Planning Officer:	Michael Eastham
Planning Application Ref:	BN/84/20/PL
Location:	Land at Angels Nursery, Yapton Road, Barnham, PO22 0AY
Description of works:	Application for variation of condition 2 (approved plans) imposed on planning permission BN/93/19/PL for the development of 95 dwellings; and consequential changes to other conditions following commencement of development.

Mark Warwick
Tree Officer / Parks and Greenspace Team

SITE LAYOUT P19-0723_10P

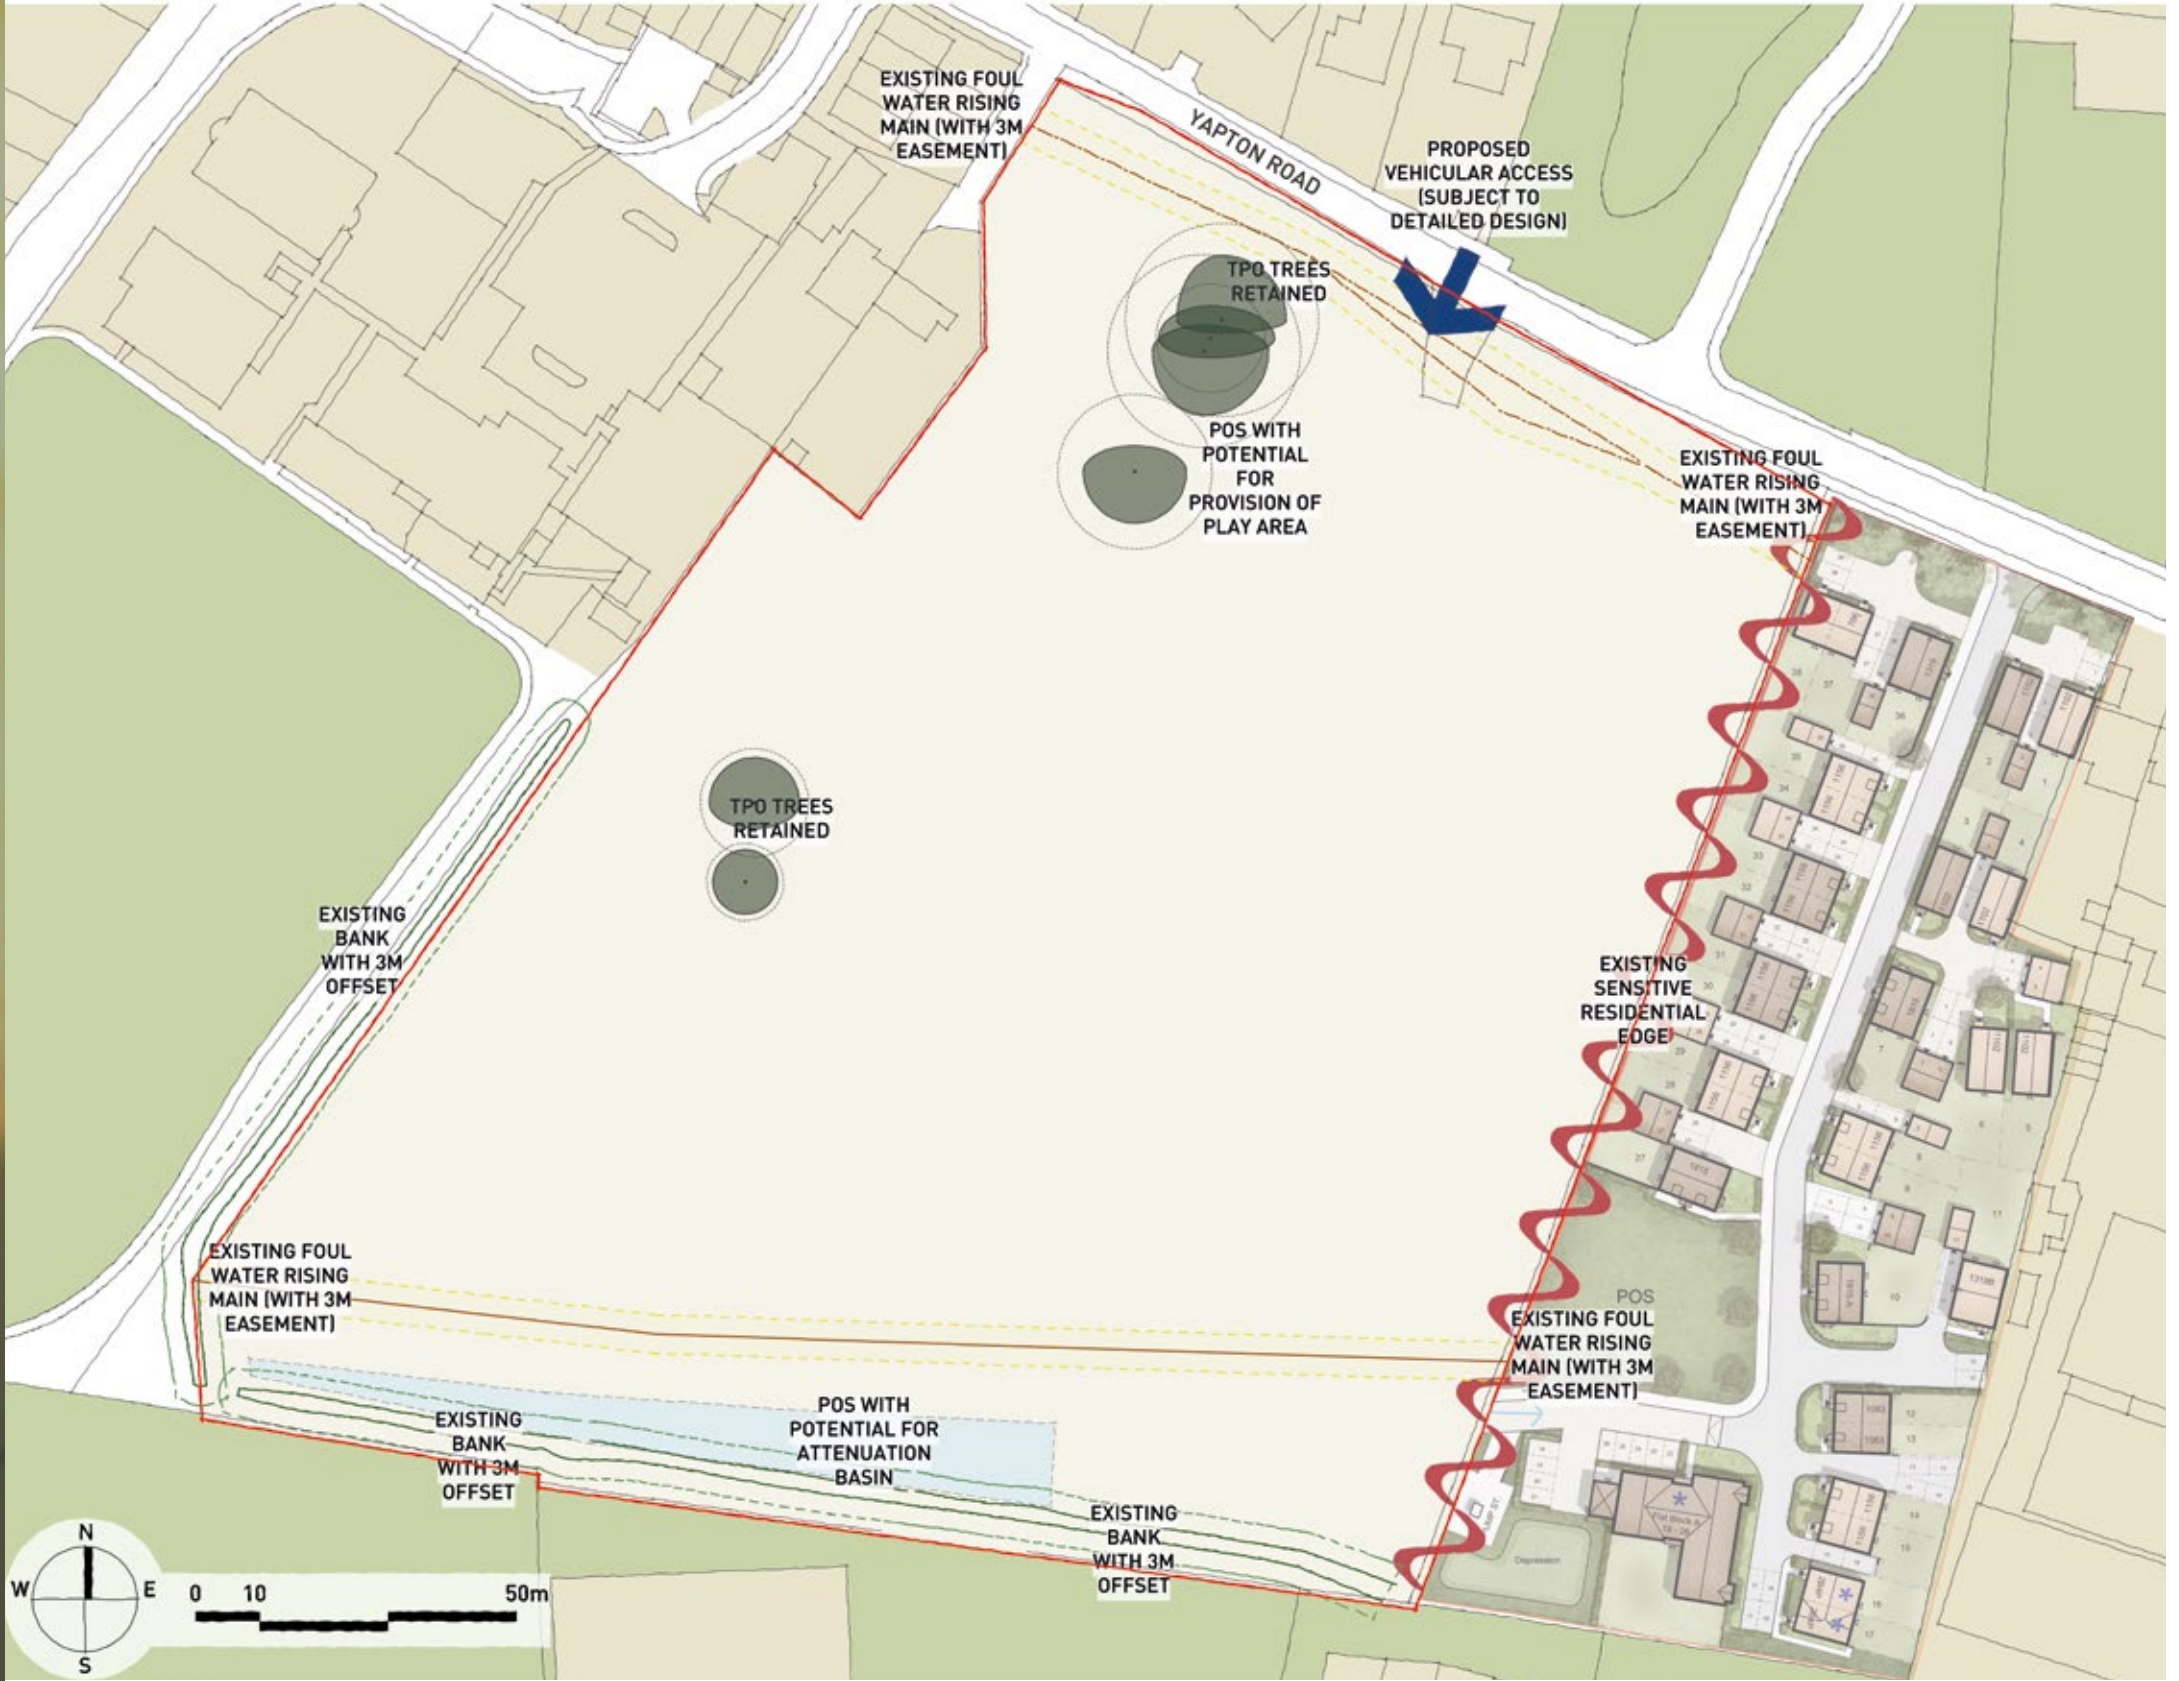
- Site layout P19-0723-10 Rev P
 - Site layout P19-0723-10 Rev Q
- As a general principle of design, careful consideration should be given to the intended land use beneath existing canopy of established trees and the potential for further tree growth. With such a large and open site to work with I would expect a layout proposal to have placed great emphasis on eliminating future 'pressure to prune' of retained trees. Furthermore, there would need to be a compelling argument in favour of any Root Protection Area (RPA) incursion as this site clearly lends itself to a harmonious design that avoids any direct interference with established trees of current and future landscape value. This is especially relevant where there are relatively few established trees of moderate-high quality, as is the case here.

- In respect of Site layout P19-0723-10 Rev Q, I can simply re-iterate comments made in relation to Rev P as I observe no material difference in arboricultural implications from the latter:

- The intrusion into the RPA of T64 oak and T65 oak (both TPO) is both unsatisfactory and avoidable. These trees need to be given plenty of room to develop into late-maturity without coming under pressure to prune or remove. **UNRESOLVED.** Pruning to facilitate construction now proposed on W aspect of T12 involving crown reduction of 2metres. Future residential pressure to prune further is highly likely due to shade-bearing.

- The group of T85-T87 incl. poplar (TPO) are a management concern post-development being so close to residential dwellings. The proposal of play areas in and about the crown spread of those trees is ill-advised from a safety perspective as well as curtailing their growth potential. **UNRESOLVED.**

- There will need to be careful analysis of soil type when considering appropriate foundation type/depth for built structures within potential distance of influence as well as provision of no-dig construction within RPA's. It may be desirable to avoid such costly mitigation and future risk management with a more evasive design, perhaps extending the area of open space west of the treeline. **UNADOPTED.**

- The construction of an attenuation basin along the southern boundary would involve the grading of soil (excavation) from deep within the RPA of substantive tree groups G5 and G6. This is a far from ideal proposal and there is a high probability of significant harm to trees.
